Our Ref: BR/280/17/PL

**Town & Country Planning Act 1990 (as amended)
Town and Country Planning (Development Management Procedure) (England) Order 2015
Application for Planning Permission**

Development 1 No. dwelling. This application may affect the setting of Listed Buildings & affects the character & appearance of the Upper Bognor Road & Mead Lane Conservation Area.

Location Land adjacent to 8 Mead Court Mead Lane Bognor Regis

Street Scene

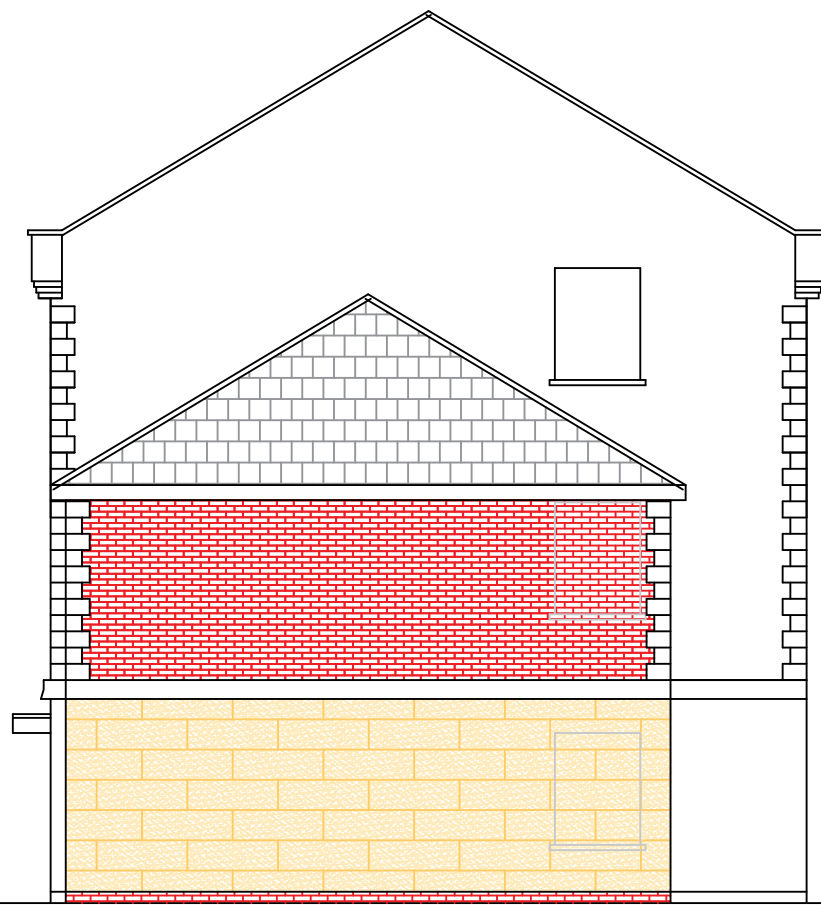
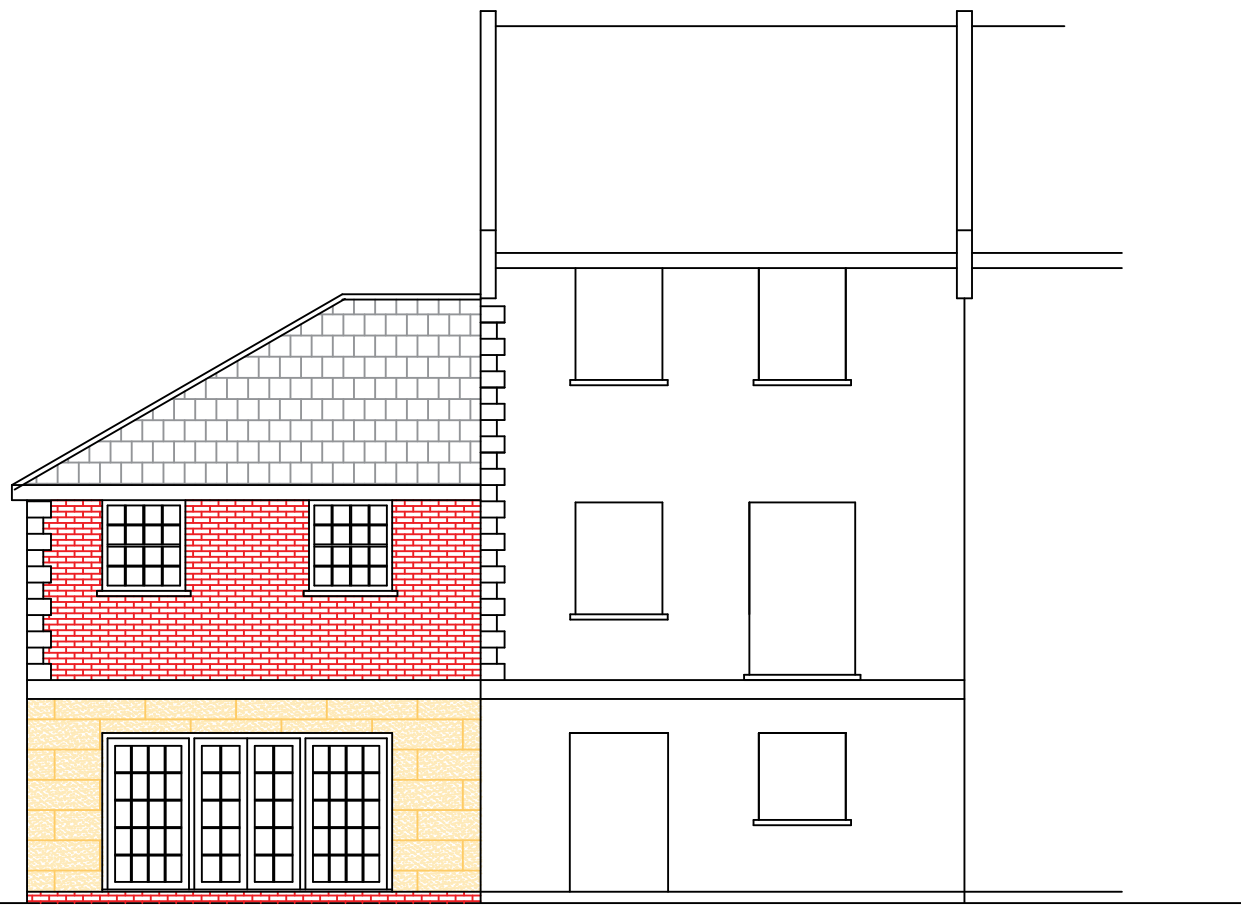
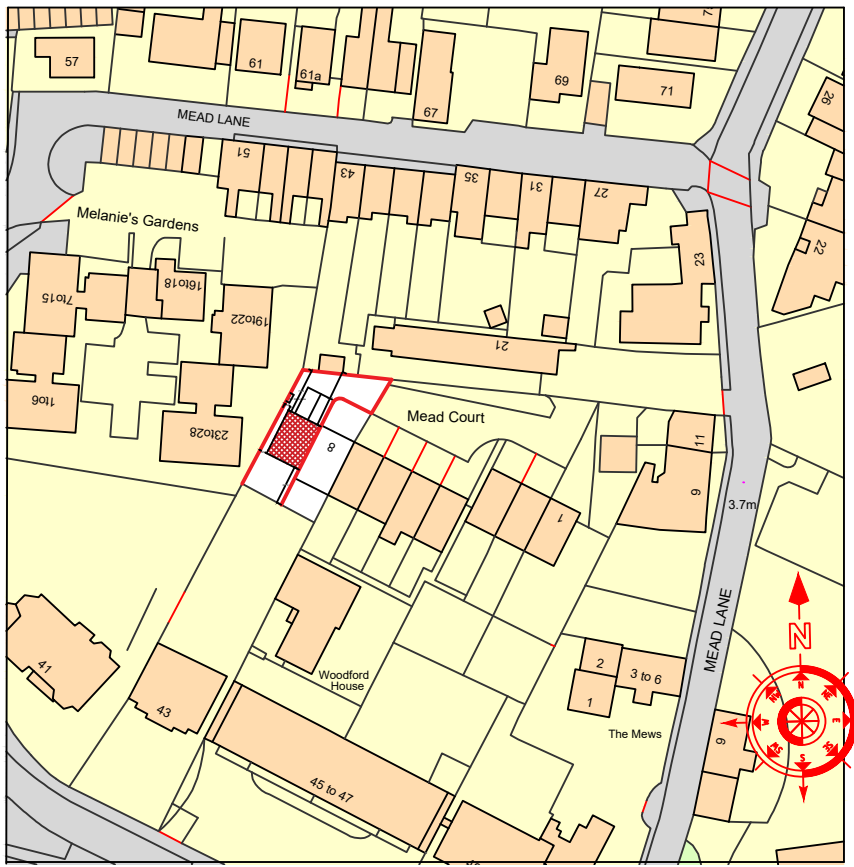
For all planning applications both residential and commercial which propose development set between existing buildings visible from the public realm it is a Local Validation Requirement to provide a street scene drawing or photomontage.

Block plan 1 : 500

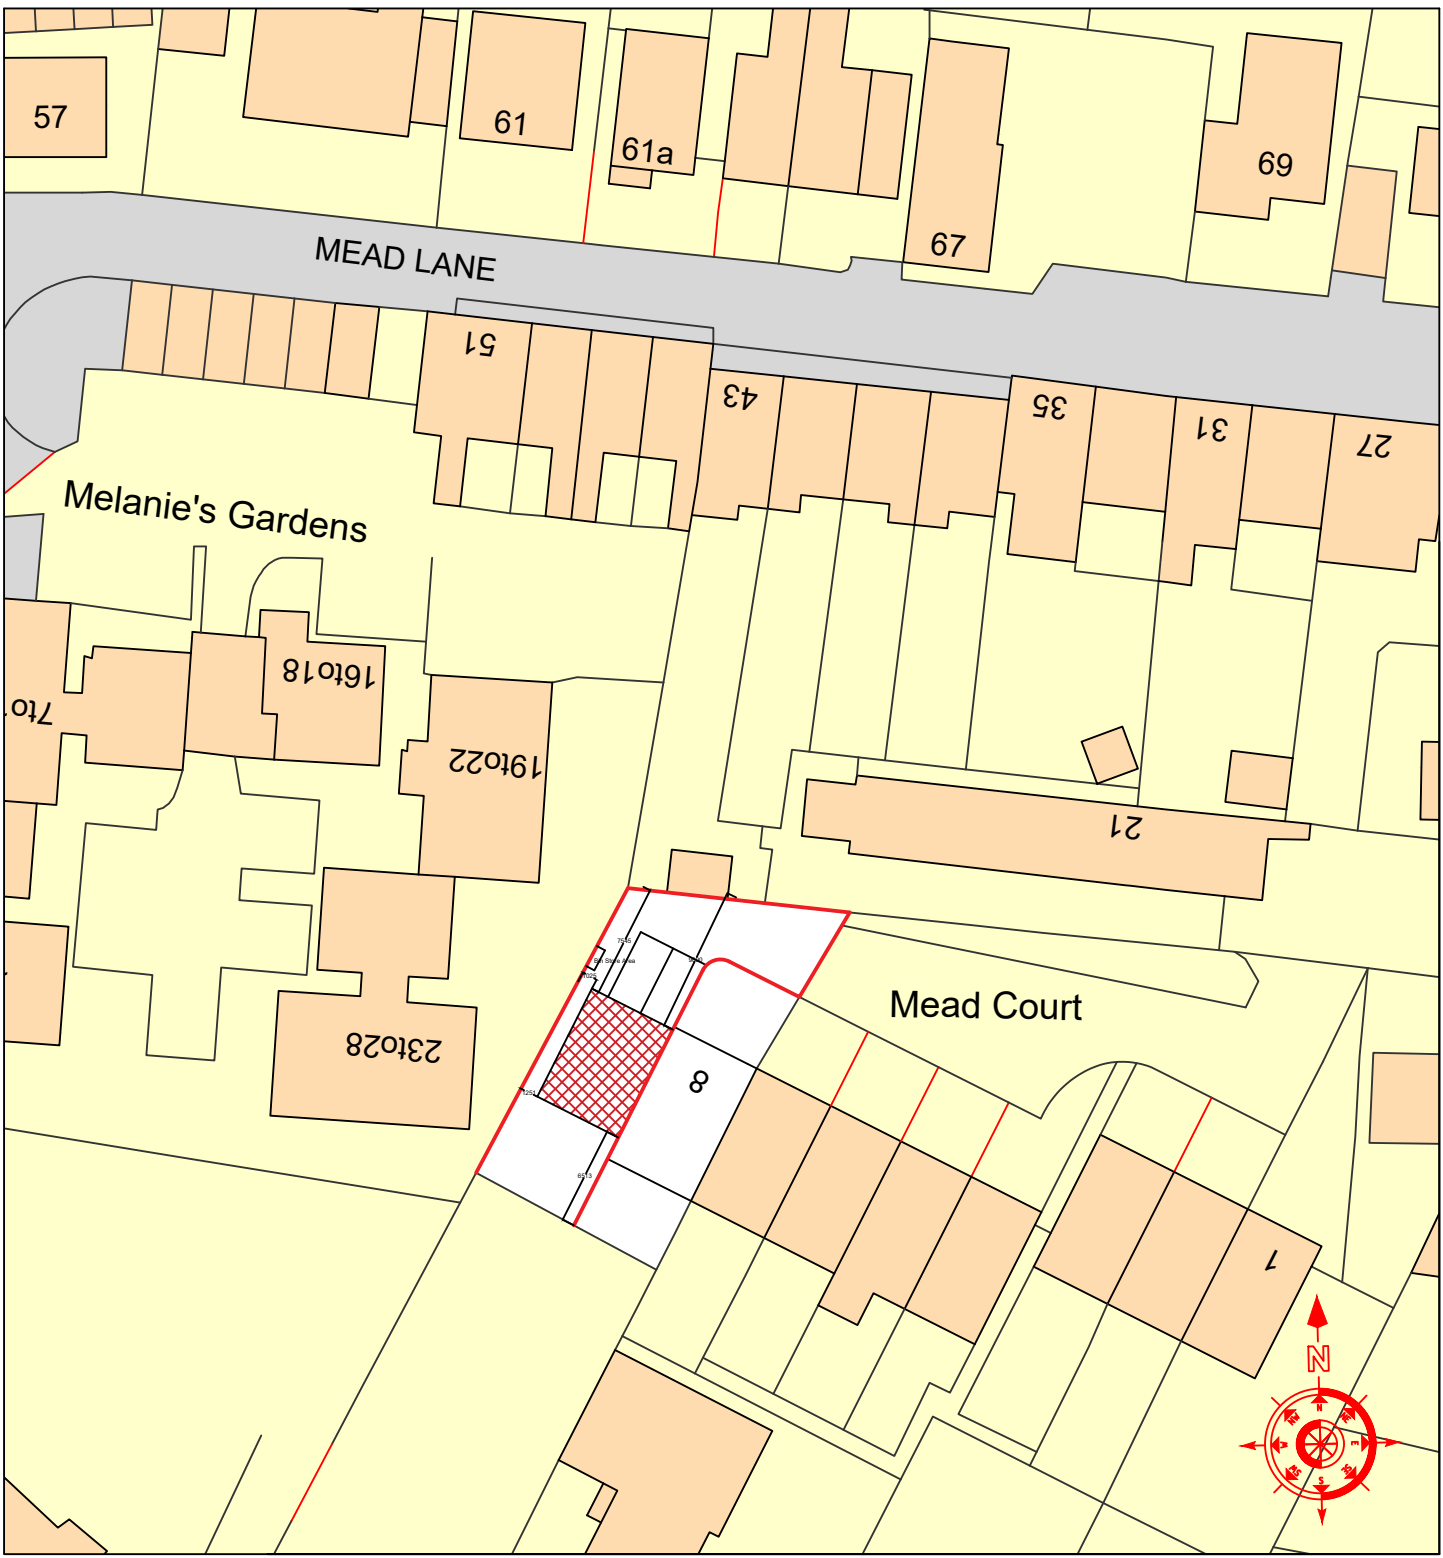
Block Plan Amend

Please submit 1 electronic or 3 paper copies of a block/site plan at a scale of 1:500 or 1:200. Further details of what must be included on the plan can be found in the National Validation Requirements. Please provide measurements from the proposal to the site boundaries and show the position of the bins.
